ROAD SAFETY AUDIT RESPONSE REPORT

A27 / A29 FONTWELL AVENUE / ARUNDEL ROAD ROUNDABOUT IMPROVEMENT

STAGE 1

30 August 2017

SCALE @ A3:	FILE REF:	DRAWN:	DATE:
	ITB11324	SH	23.05.17
DRAWING No:	ITB11324-GA-015		
PROJECT No:	ITB11324		
REV:	C

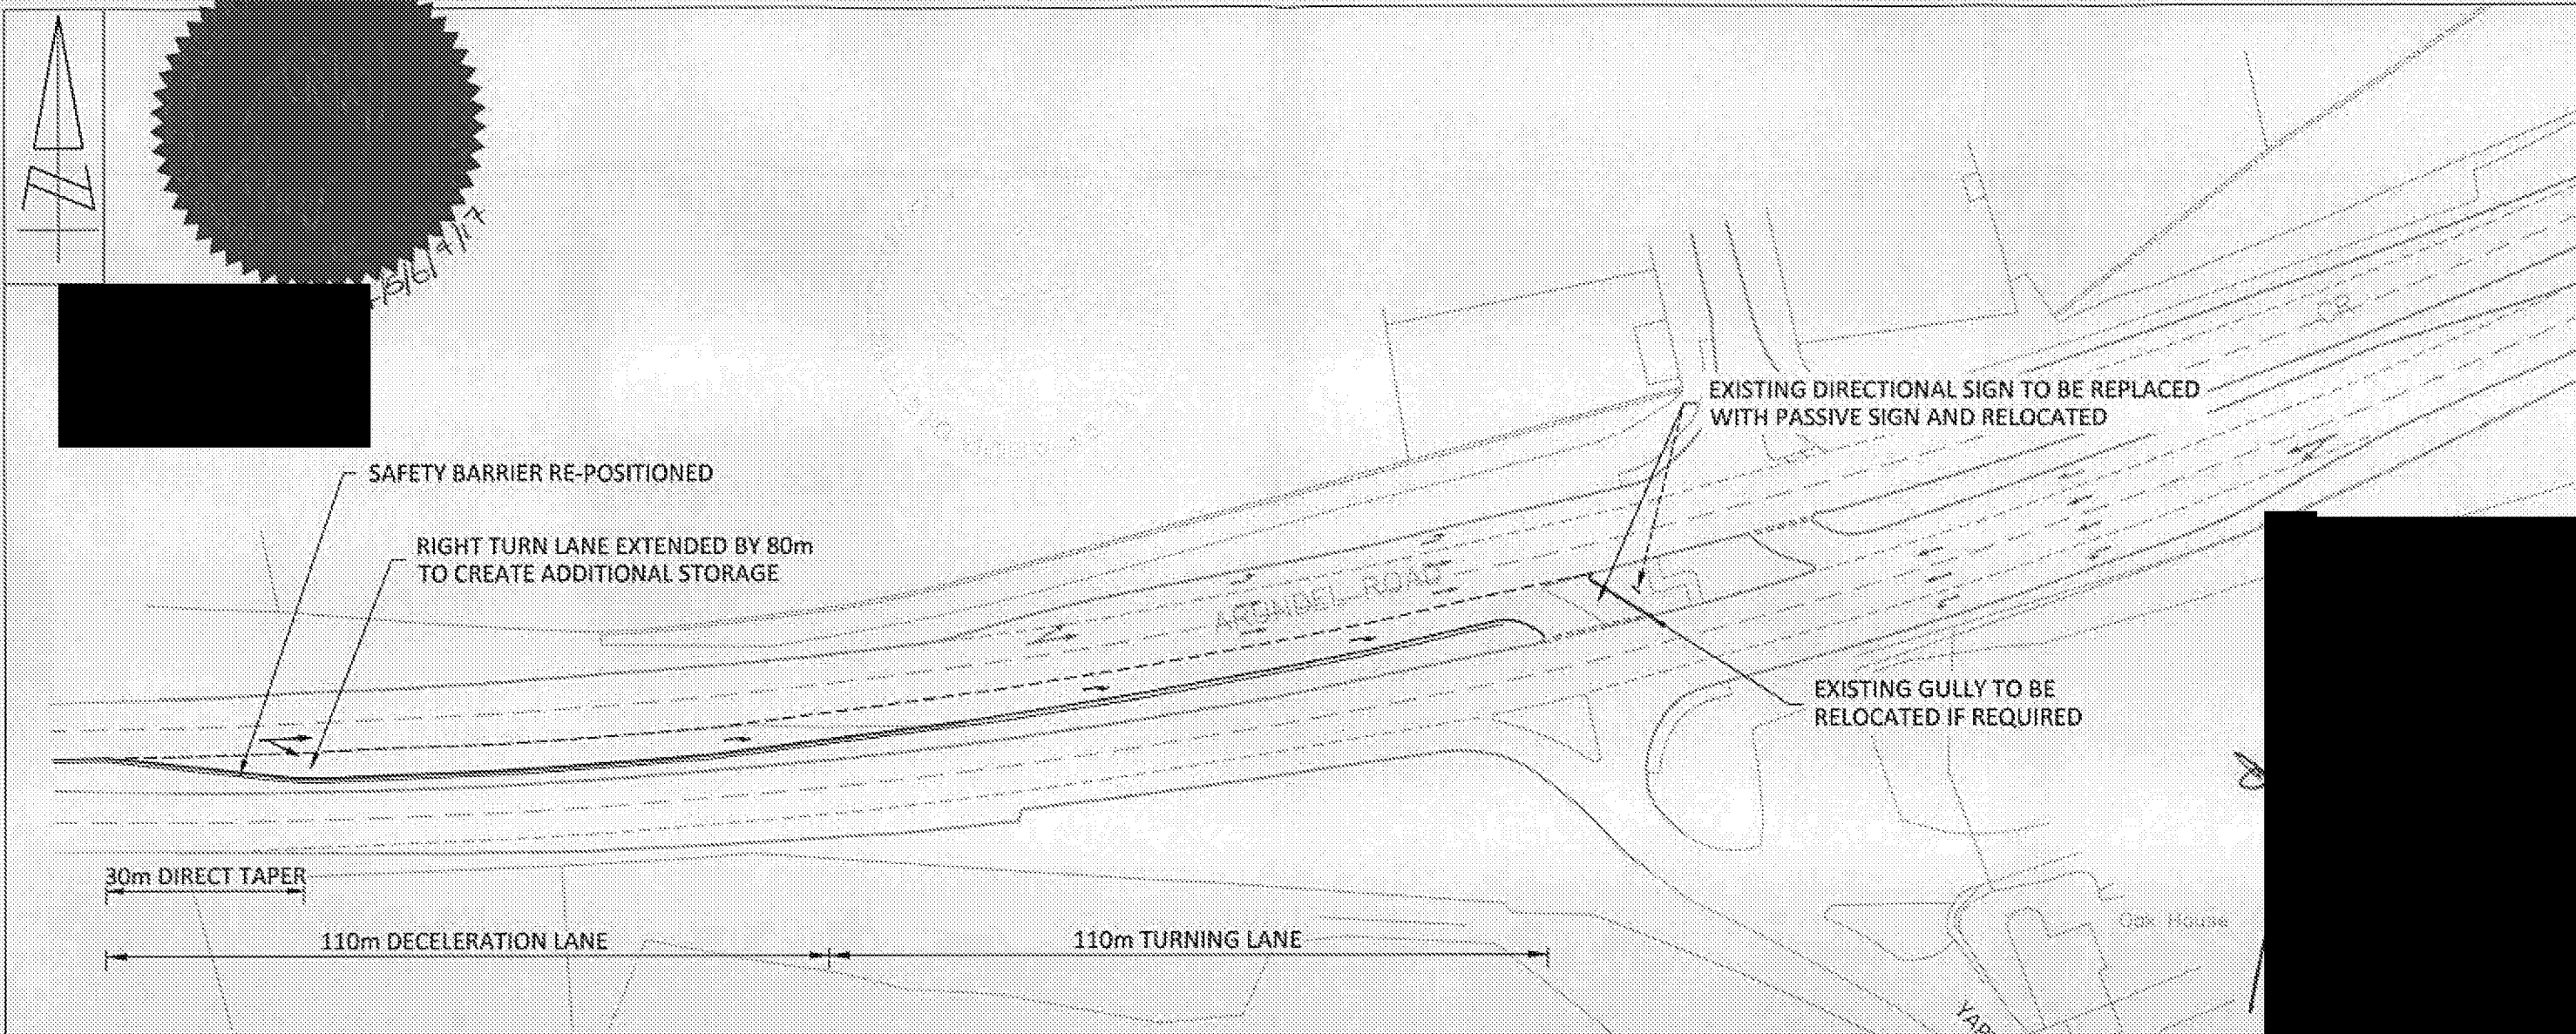
There is an existing ditch between the proposed additional entry lane and the restaurant / hotel complex, see figure 1 below, where no protection system is proposed. Vehicles that lose control and exit the carriageway may decelerate rapidly, where injuries may be severe in nature. In addition, in winter months the ditch could hold water, which could further impede the escape of vehicle occupants.

The carriageway alignment between Arundel Road and Fontwell Avenue is proposed to be changed with the kerblines being brought forward. However, there is a gully on the existing alignment, see figure 2 below, where no drainage provision is proposed. Surface water on the circulatory carriageway could lead to loss of control accidents, particularly under braking conditions.

On the A27 southwest bound approach to the roundabout, there is a manhole cover that is likely to be in the braking area on approach to the signal stop-line. This could lead to loss of control collisions under braking, particularly for two-wheeled vehicles

Entry path curvatures were provided for assessment, where the entry path from Arundel Road to the A27 for the east to west movement is greater than 100m, which is greater than the permitted maximum though it is recognised that the approved scheme also has an entry path curvature of 145m. An entry path radius exceeding 100m could lead to high entry speed and possible loss of control accidents, or conflict with circulating traffic and potential side swipe accidents.

The A29 Fontwell Avenue arm of the roundabout currently has uncontrolled pedestrian facilities, see figure 3 below. However, no dropped kerb provision is proposed, where pedestrians, particularly the mobility impaired may trip, which could lead to pedestrian accidents.

The Stopping Sight Distance (SSD) to the offside signal head is proposed at 196m, although this is below the required 295m, it is the same as with the approved scheme relating to Fontwell Meadows. Further, the SSD to the nearside signal head is proposed at 90m. In the event of the offside signal failure or queuing traffic obscuring the signal aspect, there is concern that approaching traffic will have insufficient time to react to a red aspect, which could lead to fail to stop accidents

On the southwest bound approach to the roundabout all three lanes have straight ahead arrow markings with the nearside lane also a turn left aspect. Road users may enter the nearside lane believing that they can still gain access to the A27, when instead they will be directed to the A29 Fontwell Avenue. This may lead to late lane change merge type collisions.

The signal heads are on an east west alignment, where sun dazzle could lead to red light running accidents, particularly if drivers cannot see the red / amber aspects.

Agreed – The recommendations of the Stage 1 Road Safety Audit Team, to undertake an RRRAP assessment to determine necessary protection from the ditch, will be carried out at the detailed design stage. This is noted on Drawing ITB11320-GA-015 Rev C.

Agreed – At the detailed design stage a full drainage design will be prepared and will identify any changes required to ensure the new carriageway areas are adequately drained, and that the risk of surface water ponding is reduced. This will require relocation of the gully on the existing circulatory carriageway to a position where it will accept surface water, and is noted on Drawing ITB11320-GA-015 Rev C.

- a) Coating the manhole with non-slip surfacing; or***
- b) Relocating the manhole outside of the proposed carriageway area.***

Agreed – The Arundel Road approach has been reconsidered with a view to improving deflection. Drawing ITB11320-GA-015 Rev C identifies a revised alignment which:

- ***Introduces a central hatched medium strip on Arundel Road;***
- ***Realigns the Arundel Road roundabout entry by around 1m to the north; and***
- ***Reconfigures the Arundel Road central traffic island and associated hatching.***

The revised alignment achieves a maximum EPC of 100m, which is a significant improvement on the permitted improvement scheme (145m), and complies with design standards. Drawing ITB11320-GA-017 Rev A demonstrates achievable EPC.

Agreed – Dropped kerbs and tactile pavements will be provided to improve crossing of A29 Fontwell Avenue, as shown on Drawing ITB11320-GA-015 Rev C.

Agreed – The visibility to the nearside primary signal head will be improved through provision of a mast arm mounted signal head, and the offside primary signal will be provided as a double height signal head to ensure it is visible above queued traffic, all as shown on Drawing ITB11320-GA-015 Rev C.

Agreed – Traffic signal hoods to be fitted. A note is included on Drawing ITB11320-GA-015 Rev C to identify this.
